Submission

SSD-17424905 – 20 Avon Road, Pymble

4 December 2021

Client: Owner of 57A Pymble Avenue, Pymble
Subject land: 20 Avon Road, Pymble
Lot Description: Lot 1, Deposited Plan 69541
Local Government Area: Ku-ring-gai Council
Project Title: Grey House Precinct, Pymble Ladies College
Project Description: The redevelopment of the Grey House Precinct within the grounds of the established College.

1 SHADOW DIAGRAM EXISTING June 21 - 2PM
1 : 1000

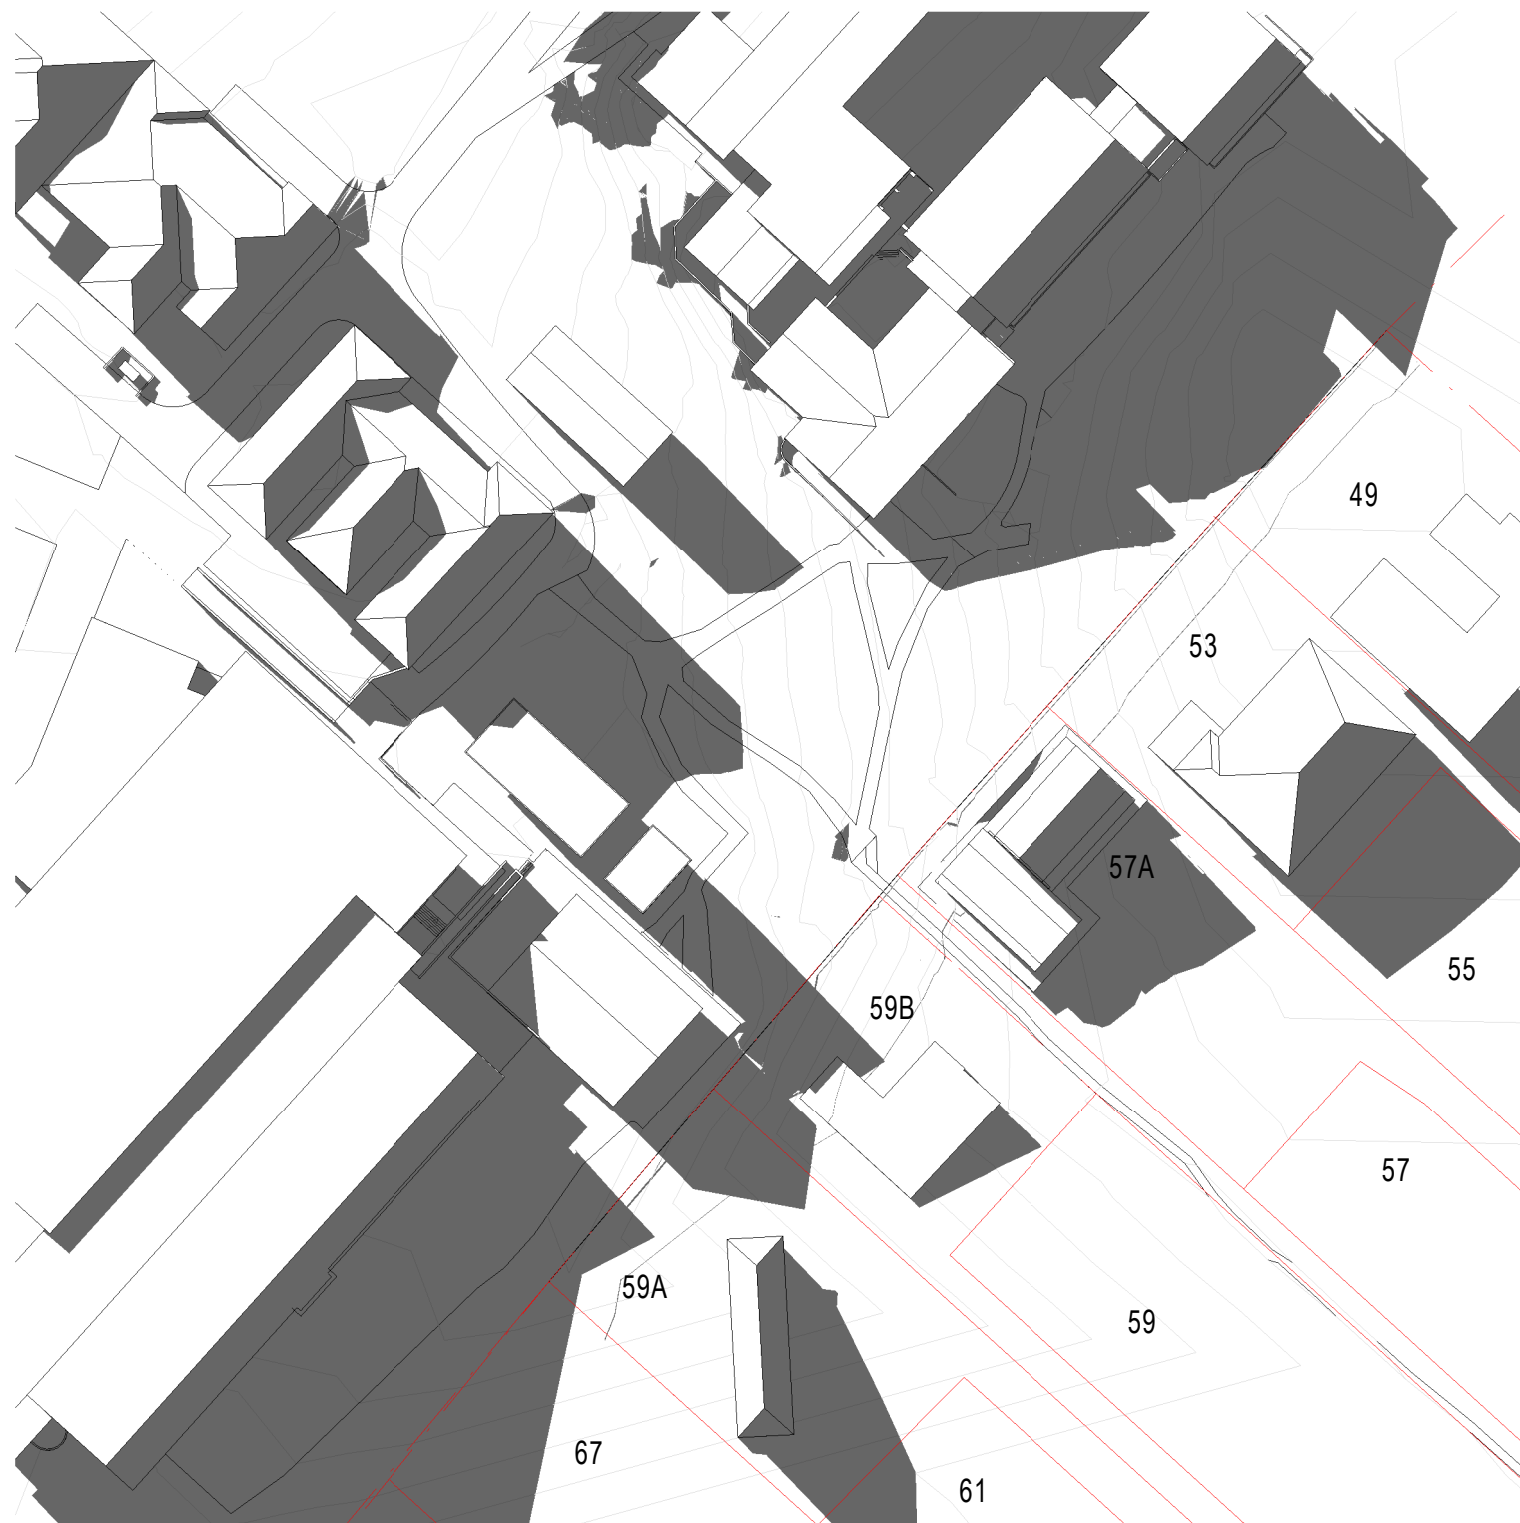
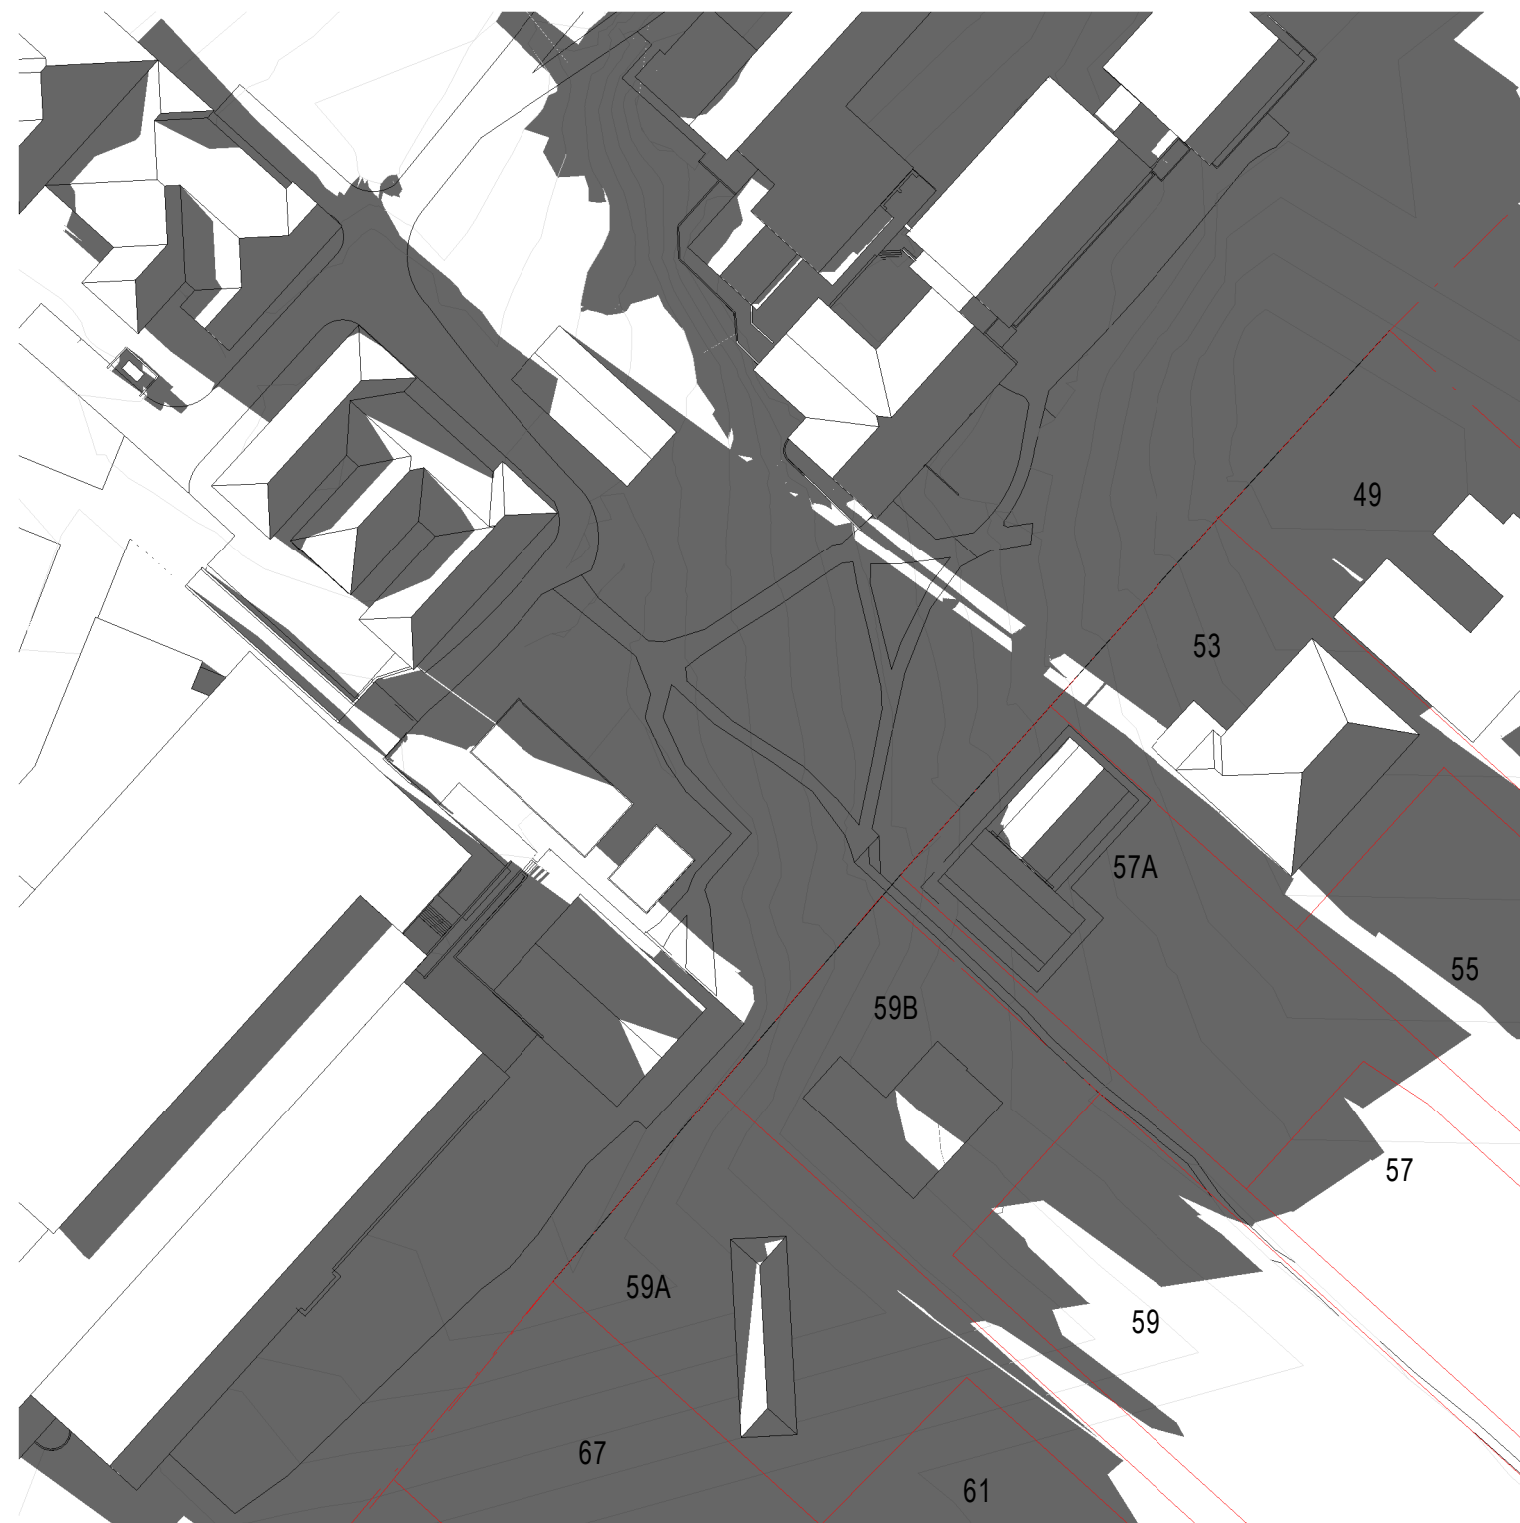
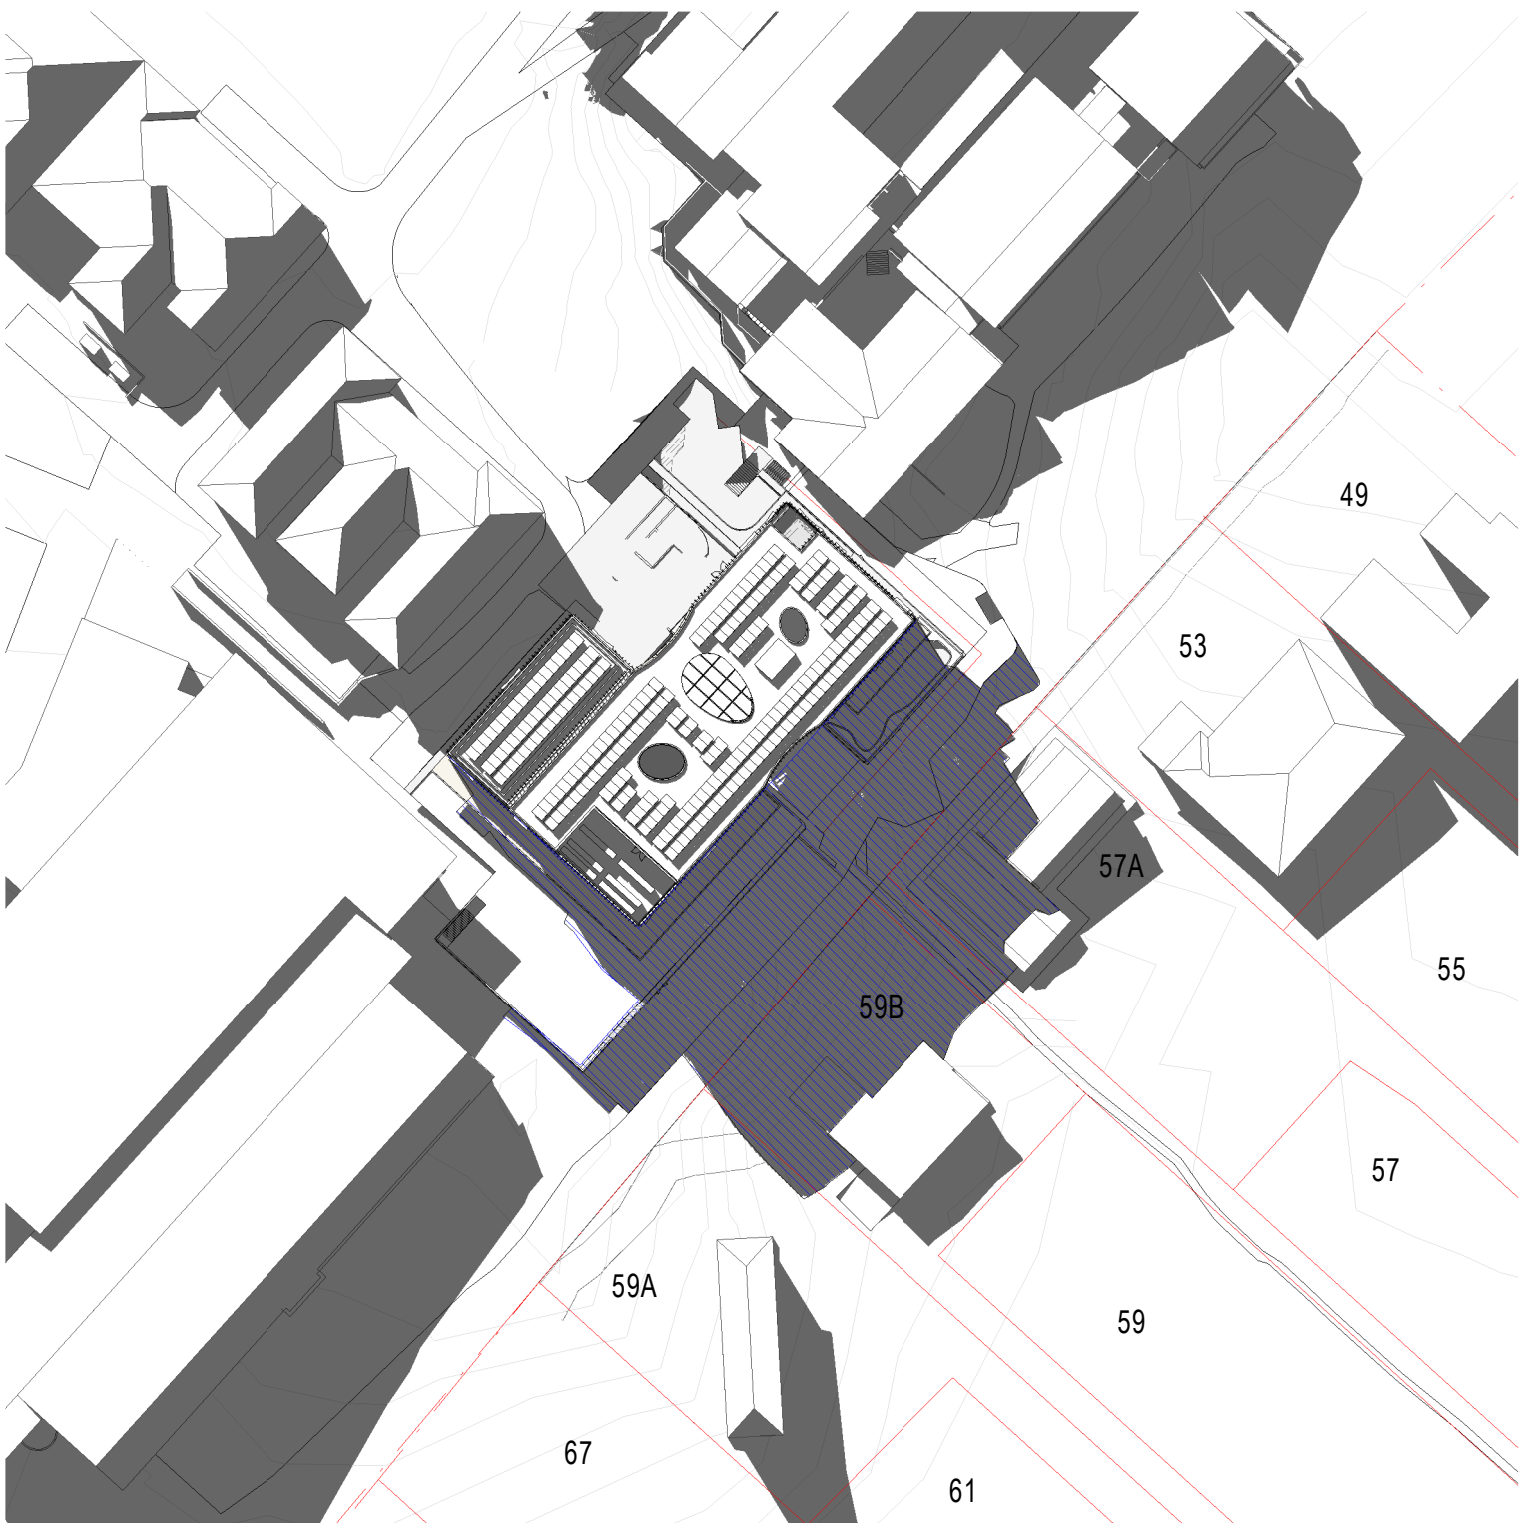
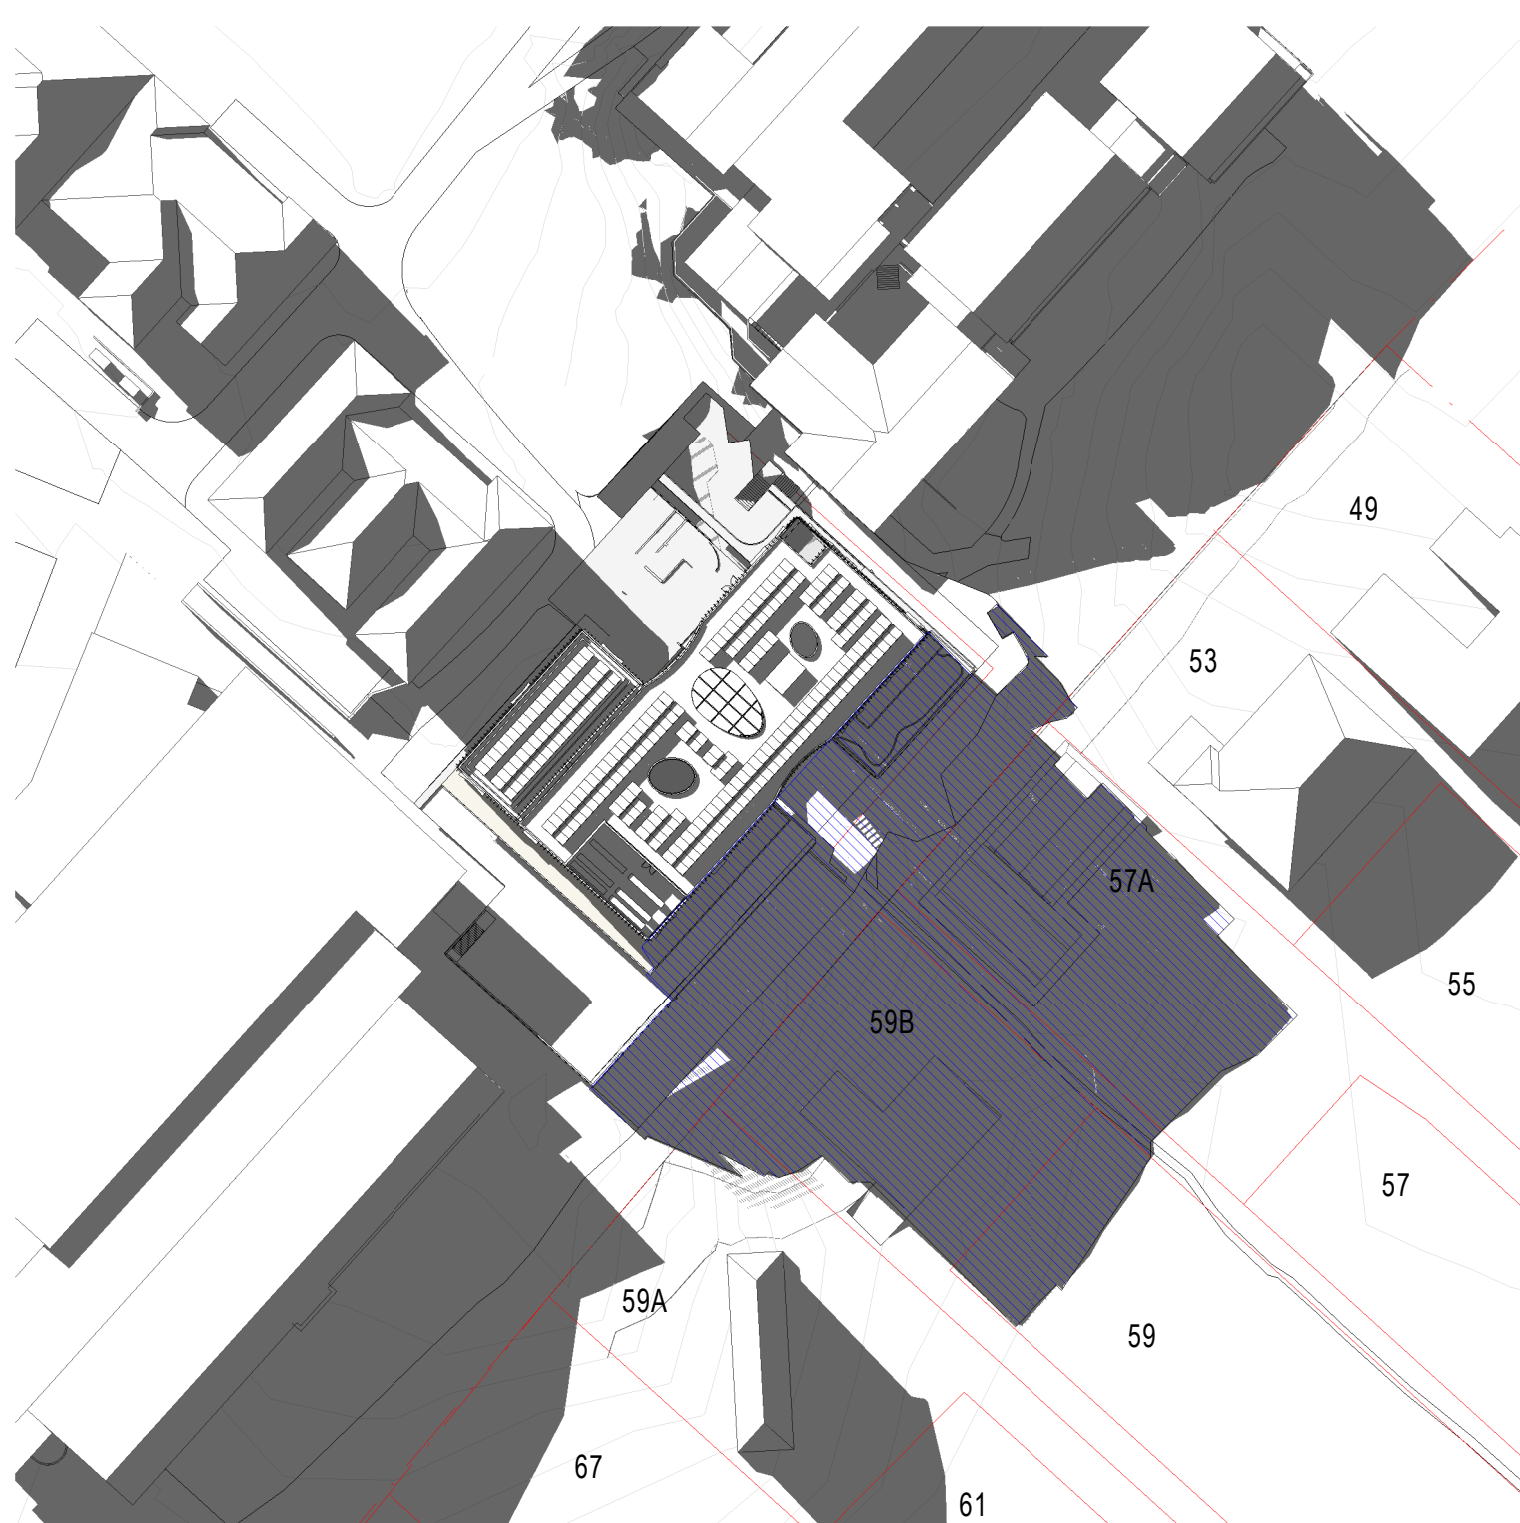
The works proposed under SSD-17424905 will substantially decrease the amount of sunlight received by the PPOS and primary living rooms of 57A Pymble Avenue from midday onwards. As per the proposed shadow diagrams shown in figures 3 and 4, there is severe overshadowing by the

Grey House building throughout the entire afternoon, caused by the minimal proposed southern setback, substantial scale and bulk, and the sloping terrain which naturally elevates the development site.

The above example is identical to the circumstances imposed by SSD-17424905 on the rear garden and north-facing internal living area of 57A Pymble Avenue, Pymble. As highlighted within the shadow diagrams prepared by BVN Architecture dated September 2021 in figure 4, the proposal will block significant sunlight from midday onwards. **This will have a detrimental impact on the current and future residents, and cannot be supported.**

- e) **Action:** Prepare shadow diagrams considering the maximum mature height and spread of the proposed trees between the Grey House building and 57A Pymble Avenue. Plantings should offer privacy without providing additional shadow for No. 57A.
Outcome: To ensure that privacy mitigation measures (ie. proposed landscape screening) does not sacrifice solar access for 57A Pymble Avenue.
